2 October 2019

Our Reference: SYD17/01338/2

Your Ref: SSD8784

**NOTICE OF EXHIBITION - STAGE 1 RESIDENTIAL, RETAIL & COMMERCIAL
240-244 BEECROFT ROAD**

Figure 3-6 Proposed Beecroft Road left in / left out access with swept path analysis

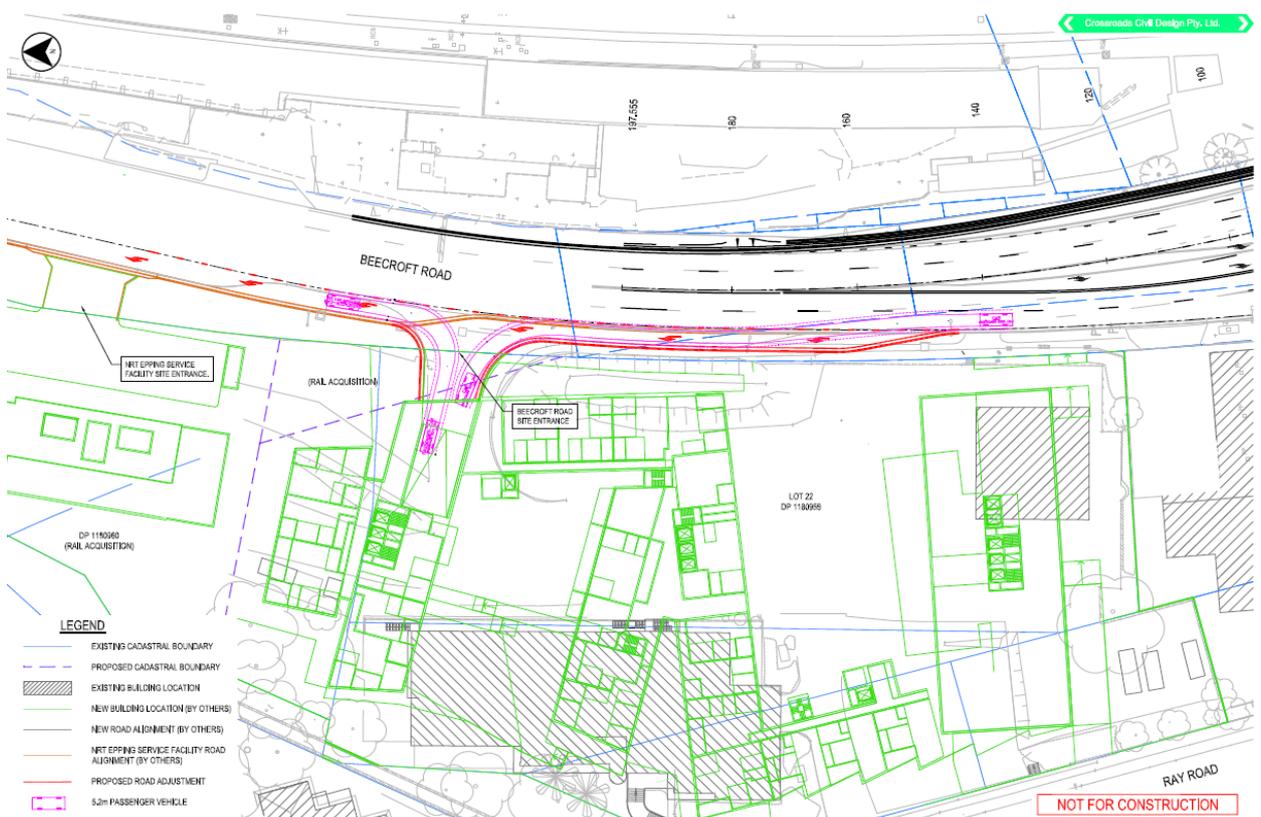
1. The proposed deceleration lane on Beecroft Road should be separated from the existing deceleration lane for the adjoining development. Roads and Maritime regards this as a safety issue due to a continuous lane creating conflict between entering and exiting vehicles. Additionally, this increases the opportunity for this lengthened lane to be used by through vehicles bypassing slower traffic on Beecroft Road.

3. Consideration shall be given to the provision of double marked lanes up to Carlingford Road from the development access point on Ray Road.
4. The Beecroft Road deceleration lane works shall be in accordance with Roads and Maritime requirements. Details of these requirements should be obtained by email at DeveloperWorks.Sydney@rms.nsw.gov.au.
